FINAL PLAT

UPLAND FLATS BY WATERMARK FILING No. 1
BEING A REPLAT OF TRACT DD OF HANNAH RIDGE AT FEATHERGRASS FILING No. 1
AND A PORTION OF AKERS DRIVE RIGHT-OF-WAY
BEING A PORTION OF THE SOUTHEAST QUARTER OF
SECTION 32, TOWNSHIP 13 SOUTH, RANGE 65 WEST OF THE 6TH P.M.
COUNTY OF EL PASO, STATE OF COLORADO

Plat V_2 redline planning.pdf Markup Summary 5-7-2021

FINAL PLAT

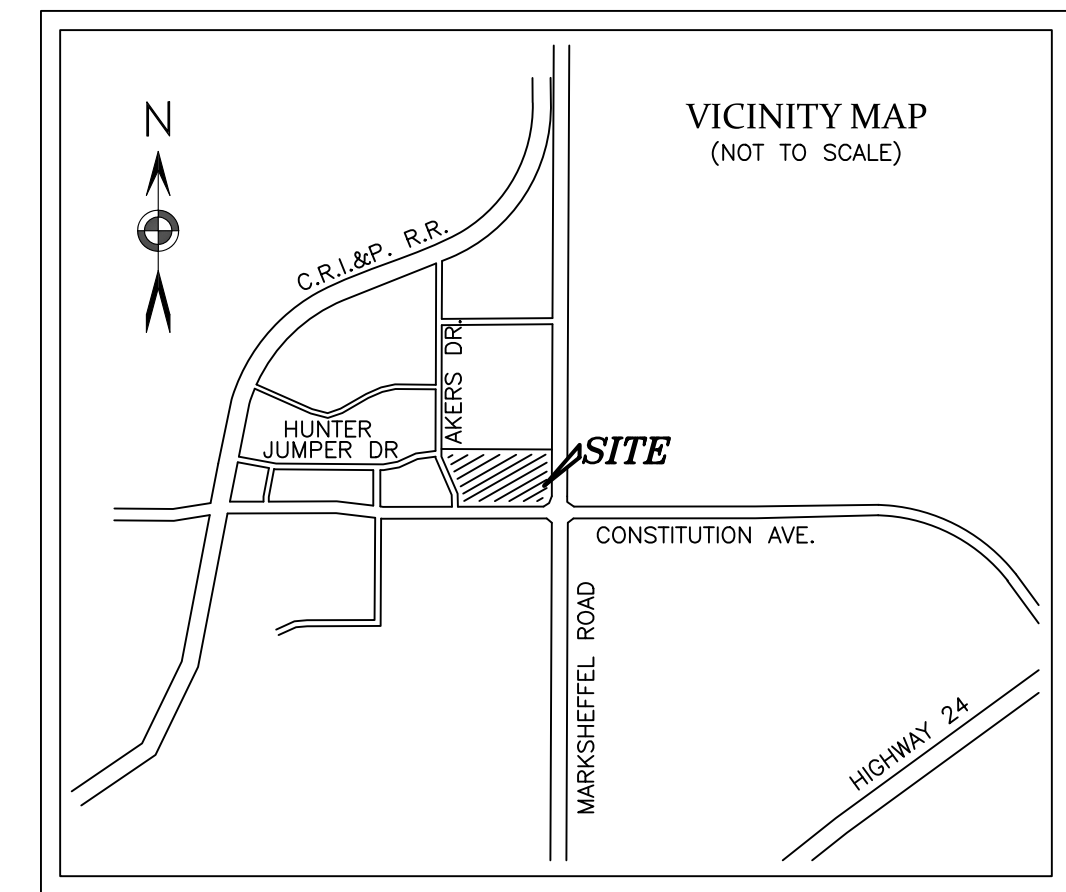
Staff will agree to delete note 29 and defer public improvements to site dev plan

Staff will agree to delete note 29 and defer public improvements to site dev plan

note may change based on comment response
